New balcony and replacement windows. This application may affect the character and appearance of the Arundel Conservation Area.

4 The Old Slipway River Road Arundel

Thank you for your internet representation made on 8th October 2019 which has been recorded as '**no objection**' with the comments as follows:

First Floor Plan + Elevations
as Proposed

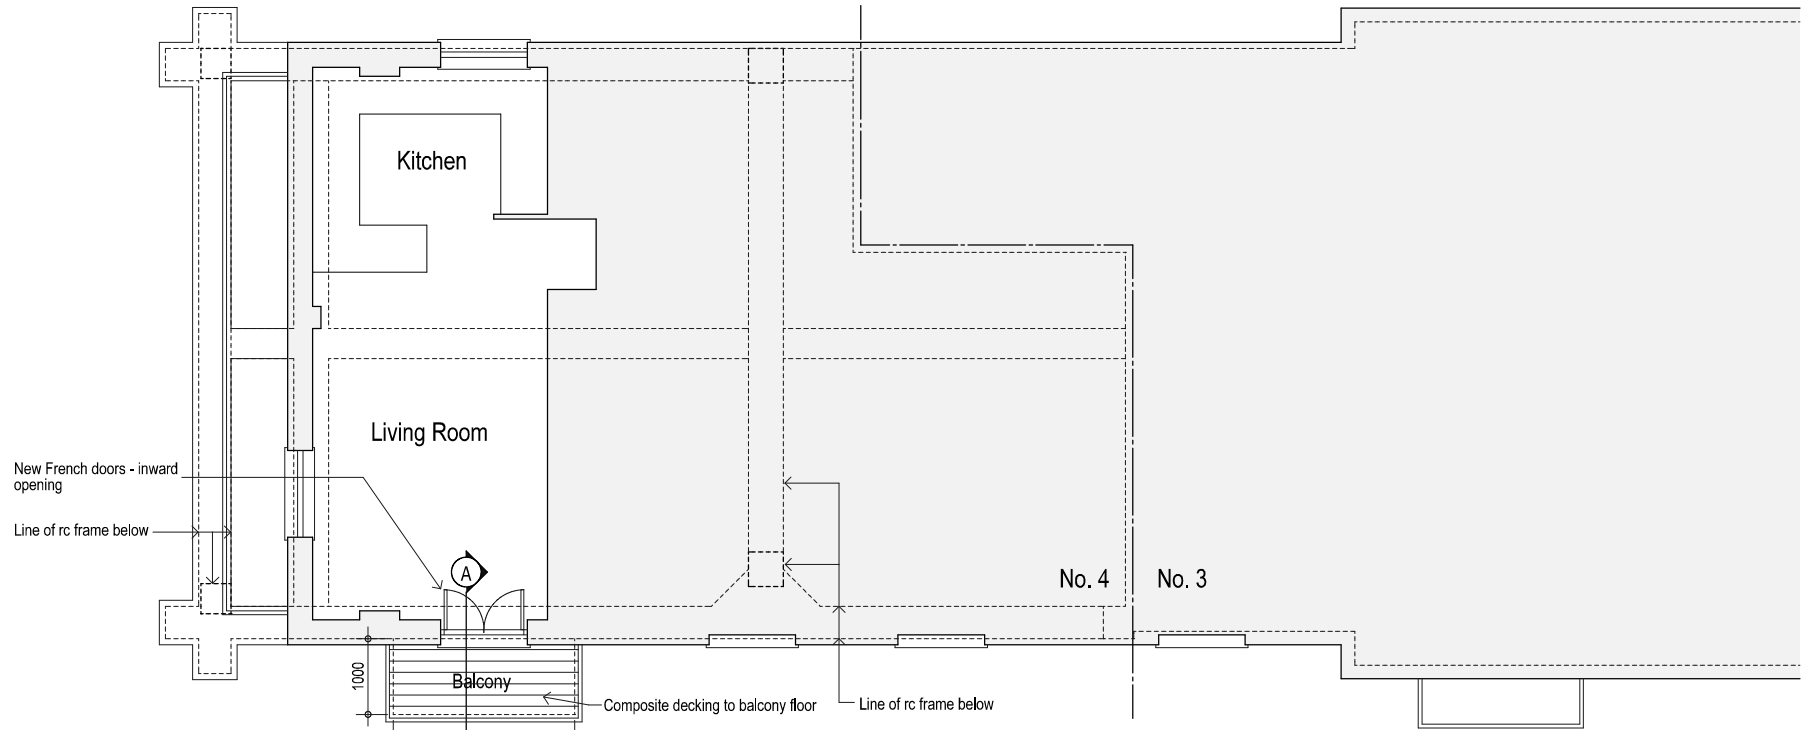
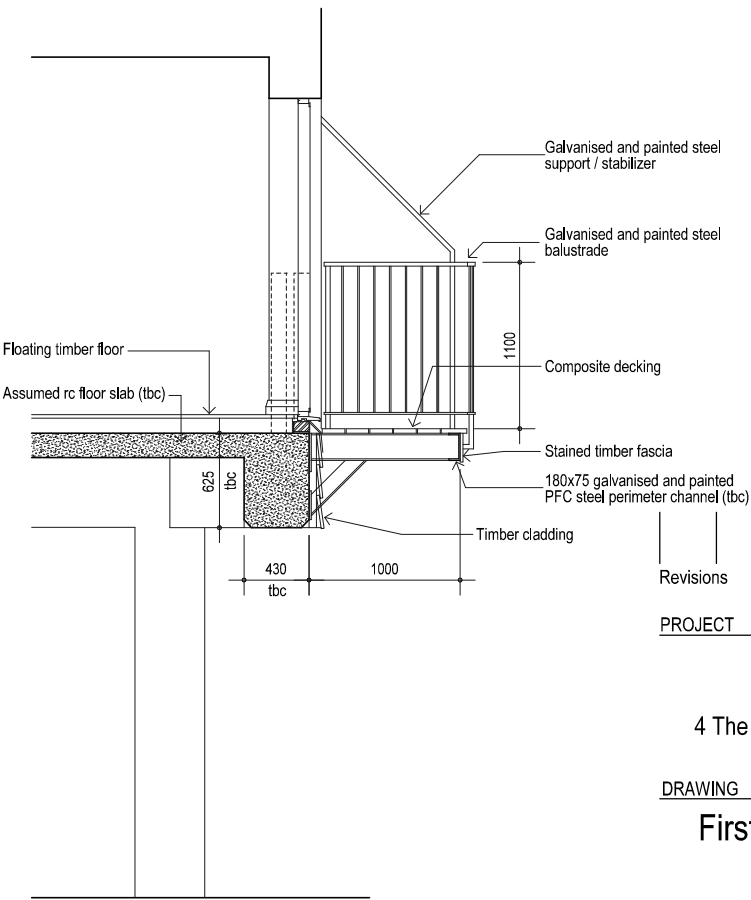
The Old Slipway occupies a prominent situation in River Road and also as viewed from the river and from some locations in Fitzalan Road.

The building dates to the late 1980's and its design is an indifferent pastiche of traditional riverside warehousing. Nevertheless, its general form is appropriate to the riverside setting and follows that of original warehouse structures and more recent development along the north side of the river between the old road bridge and the western end of Tarrant Wharf. The proposed enlarged french window opening is of a sympathetic proportion and as the applicant's agent indicates in the Planning Statement it, and the associated balcony, will form a "bookend" with the similar features at the eastern end of the river elevation of the building.

It is considered that there will be no harm to the character or appearance of the conservation area and that the proposal complies with the relevant paragraphs of the NPPF 2019 and policies contained in the Arun District Local Plan 2018 relating to the protection of designated heritage assets.
